**Ribble Valley Borough Council**

## **DELEGATED ITEM FILE REPORT - REFUSAL**

<b>Application No:</b>	3/2015/0245/P
<b>Site:</b>	Wolfen Lodge, Fish House Lane, Chipping, PR3 2GR
<b>Development Proposed:</b>	Proposed side extension
<b>Target:</b>	21 <sup>st</sup> May 2015

as proposed

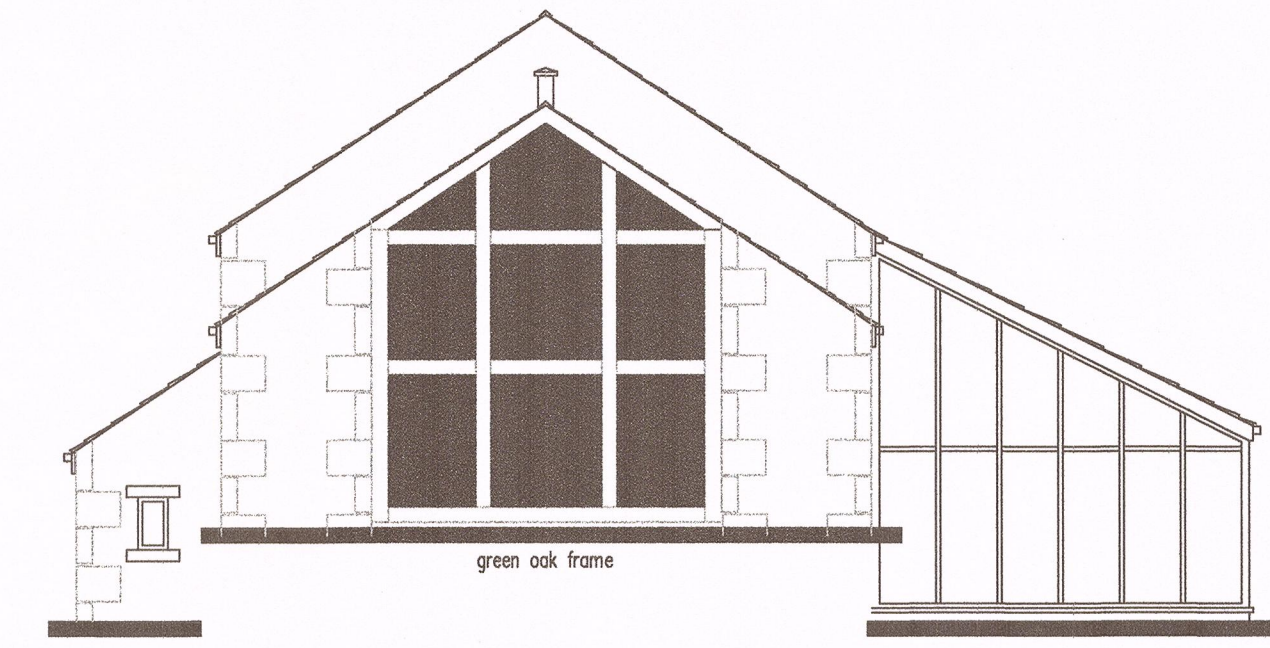
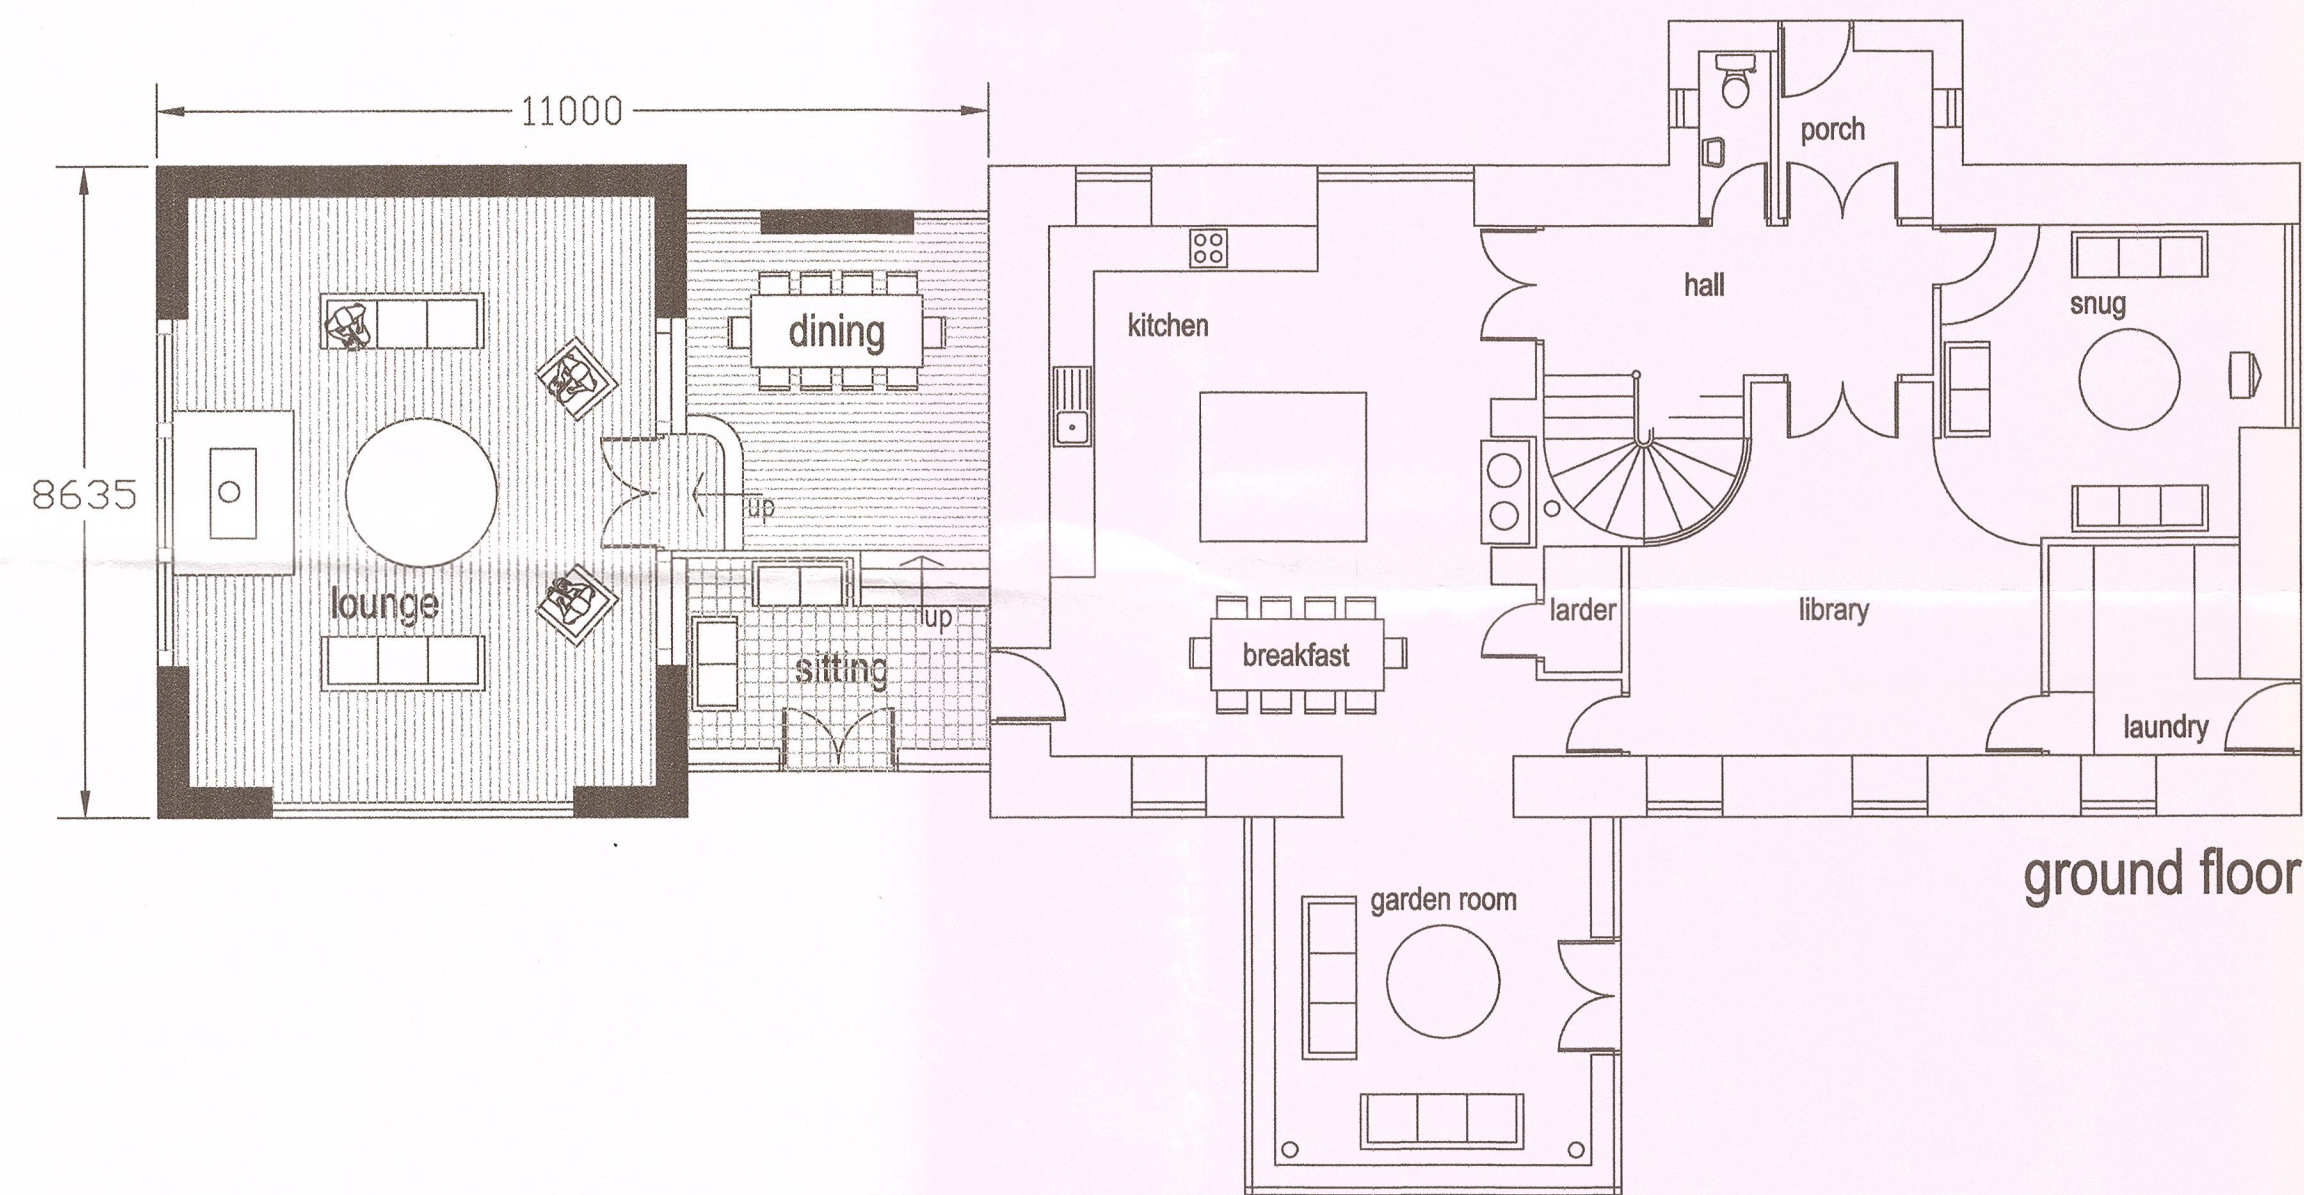
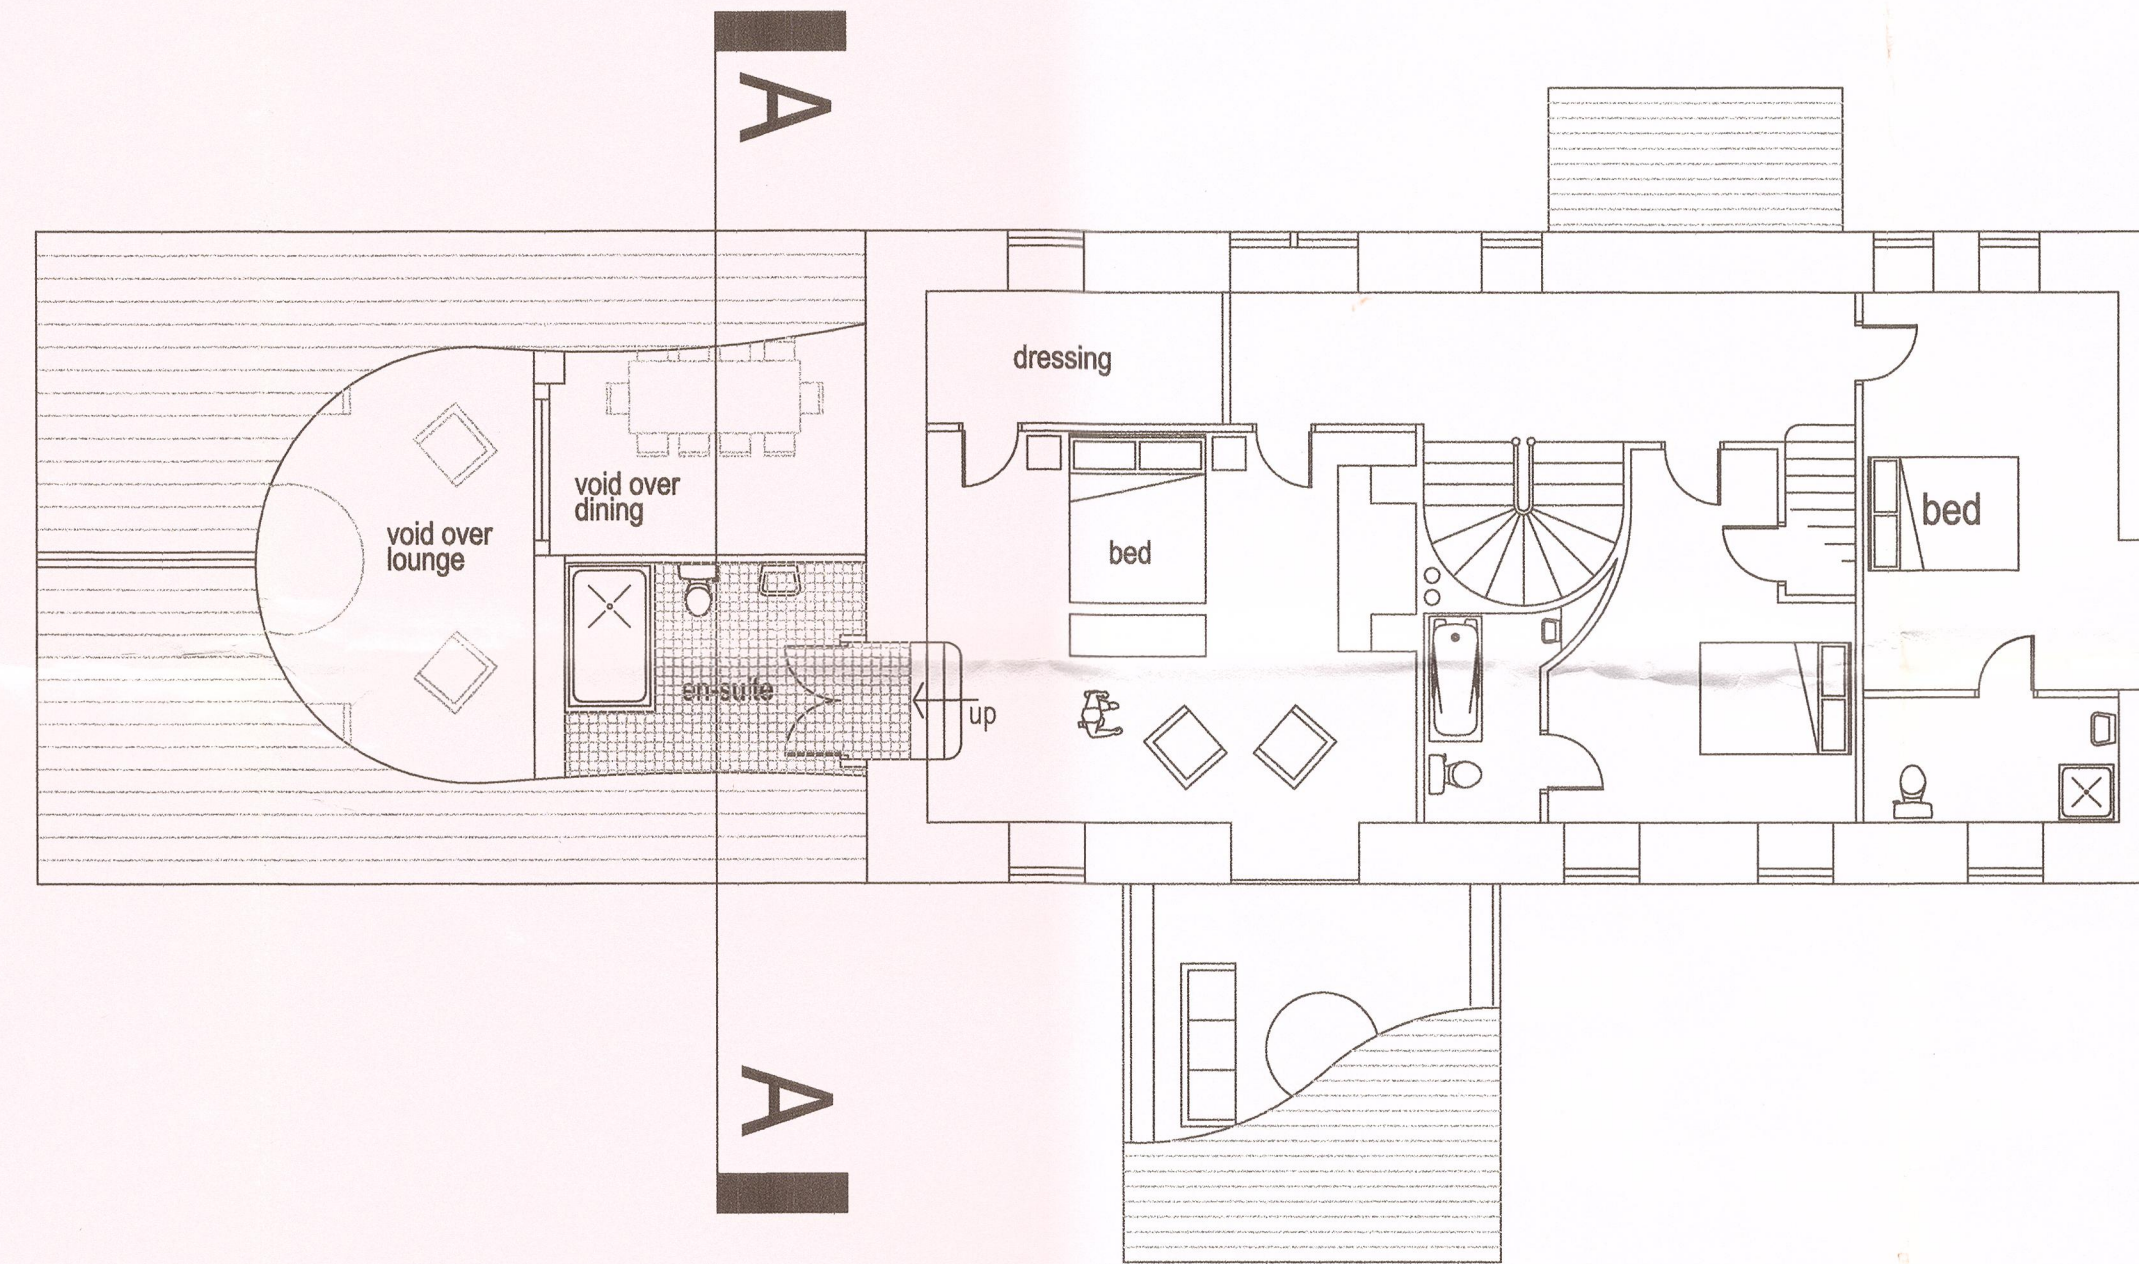
The proposed extension would project from the north gable of the existing building and would measure around 11m x 8.6m. It would have gable roof running parallel with the main roof and would have an eaves height of 2.5m and a ridge height of 5.75m. The addition would provide additional lounge, dining and sitting areas and would include the introduction of an internal flue at the north end of the extension. The proposed development would be to the side of the existing property and would not be visible from long-range. However, it would be visible from Fish House Lane and public footpath no.110 which passes along the front of the site.

In relation to its scale and form, the extension would have lowered eaves and ridge compared to the main building and would be set back from the front and rear walls at the point it joins the gable elevation of Wolfen Lodge. However, the proposed development would have a void over the proposed living area resulting in a height of around 7m at the point it would join the main building and would have a height equivalent to a 1 ½ storey building. Furthermore, the depth of the extension increases to the north to reflect the width of the main building. The extension would increase the length of the property to 28m leading to a significant increase in the scale and mass of the building. It is considered that the proposed extension would not be clearly subservient to the main building and would be a bulky and incongruous addition that would substantially increase the mass of the host property. Additionally, whilst the extension would continue the linear form of the building, it would complicate the simple front elevation of the property and would unbalance the building due to massing to the north side.

Agricultural buildings are characterised by a limited number of window and door openings. Nonetheless, it is noted that the conversion of the agricultural barn has resulted in the creation of a number of additional window and door openings creating a somewhat ordered and symmetrical fenestration of the existing building. The proposed extension seeks to introduce large timber framed glazed elements to the front, rear and gable elevation and a number of roof lights to the front and rear roof slopes. This would be neither in keeping with the original building or the building as it stands today and would not respect the existing ratio between solid wall and window. These proposed openings do not sit comfortably with the building, would not reflect local vernacular or style and devalue the character of the traditional farm building and that of the surrounding environment.

The property lies adjacent to open water and woodland which is ideal bat foraging habitat. The Council's Countryside Officer has stated that the provision of three roosting features within the build of the extension would comply with NPPF and Core Strategy requirements for the net gain of biodiversity. The applicant has submitted details of three Swegler bat tiles on the east and west facing elevations of the extension which are considered acceptable.

In conclusion, the proposed extension, by virtue of its massing and design, would devalue the character of this traditional farm building and that of the surrounding environment. The extension is considered to be wholly insensitive to the original form of this traditional barn and its character, appearance and historic significance. Moreover, if allowed the development would set a dangerous precedent for the acceptance of similar unsympathetic extensions destroying the character and appearance of other barn conversions which would be both contrary to Policies DMG1, EN2, DME4 and DMH5 of the Ribble Valley Core Strategy.
